3 June 2024

## **SSD-67924472 LIGHT HORSE INTERCHANGE WAREHOUSE - LOT 3**

I refer to the Department's email of 17 May 2024 regarding the Environmental Impact Statement (EIS) for State Significant Development SSD-67924472 Light Horse Interchange Warehouse - Lot 3 for 'Construction and operation of a warehouse facility on Lot 3 of the Light Horse Interchange Business Hub' at 165 Wallgrove Road and 474 Ferrers Road, Eastern Creek (Lot 10 DP 1061237, Lot 5 DP 804051) in the Blacktown City Council local government area (LGA). Submissions need to be made to the Department by 17 June 2024.

Figure 1: Site Plan

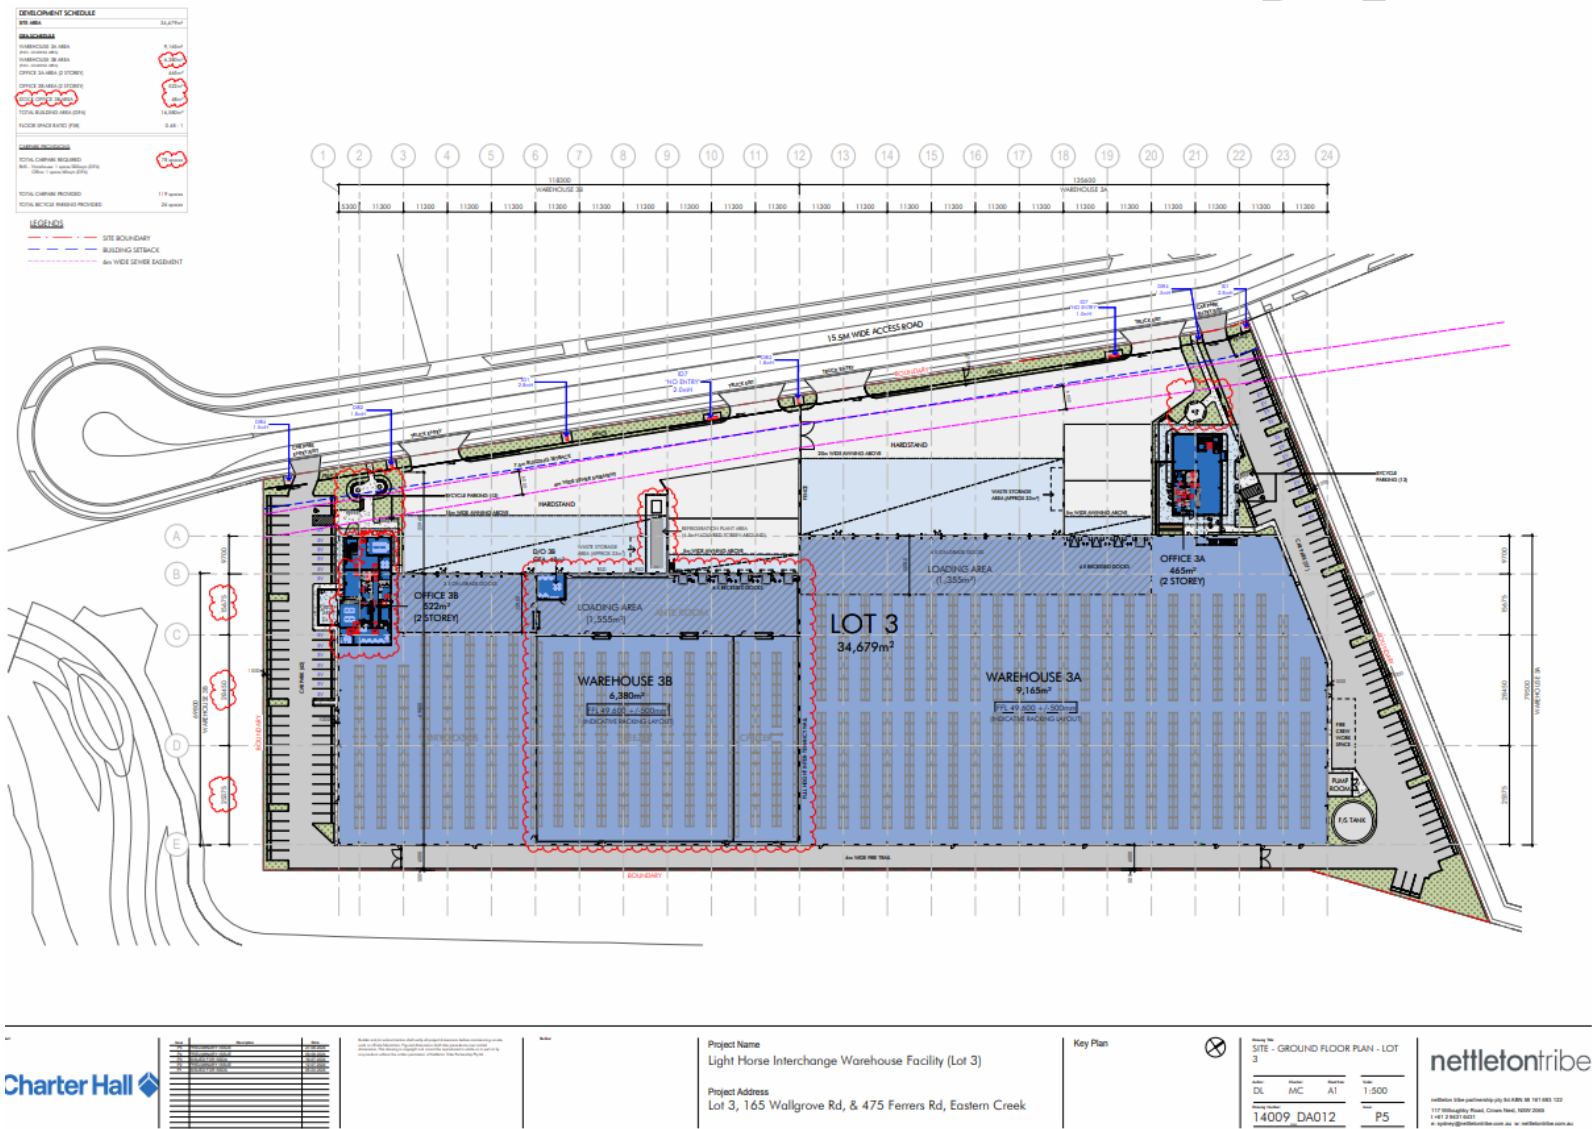
The Architectural Plans do not appear to show the provision of a padmount substation on Lot 3.

The below updated Site Plan from Endeavour Energy's G/Net Master Facility Model shows there is now electricity distribution infrastructure in the 'New Estate Road' which unless located in a public road / reserve will need to be protected with an appropriate form of property tenure as detailed in the attached copy of Endeavour Energy's 'Land Interest Guidelines For Network Connection'.
